From: Laura Gibbons
Sent: 04 June 2018 13:40
To: Planning.Responses
Subject: RE: Planning Consultation on BR/138/18/DOC

Comments relating to Condition 3- surface water drainage

Registered: 14-MAY-18
Site Address: Villa Maria Campbell Road Bognor Regis PO21 1NW
Description of Works: Application for approval of details reserved by conditions imposed on planning reference BR/270/16/PL relating to condition no. 3 (Drainage), 4 (Arboricultural Protection Measures) & 6 (Materials & Finishes)

Proposed Site Plan

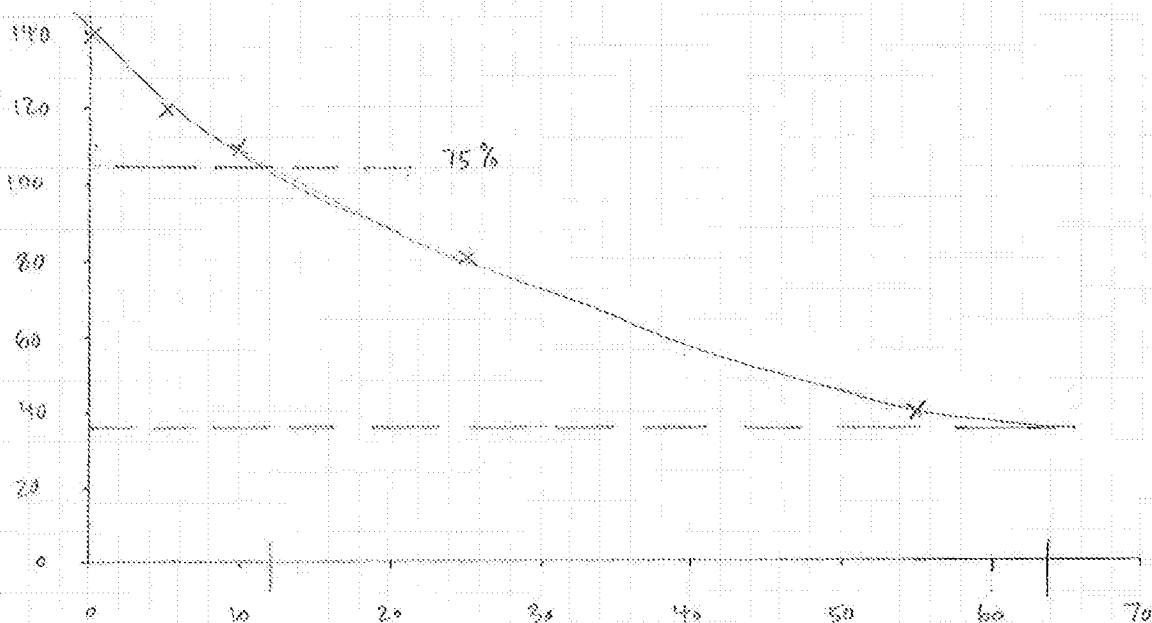
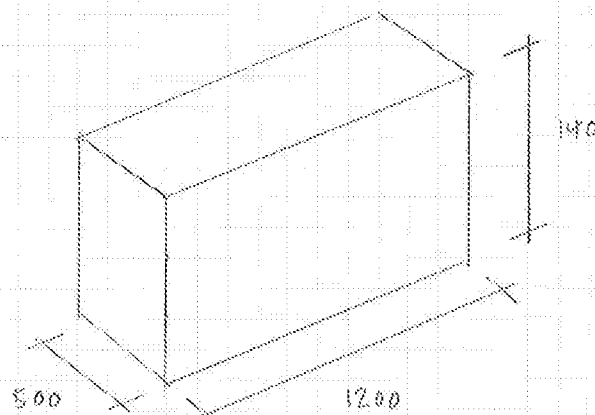
The submission details percolation test that evidence suitable rates of infiltration for soakaways to be used are prevalent. However, the submission then goes on to state there is insufficient space for soakaways so discharge to sewer will occur. This is not acceptable.

Having reviewed previous submissions it is clear that the pre-commencement condition was not abided by. This is not however now justification to not follow the hierarchy for sustainable drainage.

There are possibilities to use permeable paving on site, and following conversations with building control to possibly drain some roof water into these.

Based on this, I do not recommend that the condition is discharged. And would recommend the developer contacts us to discuss how to correctly drain the site.
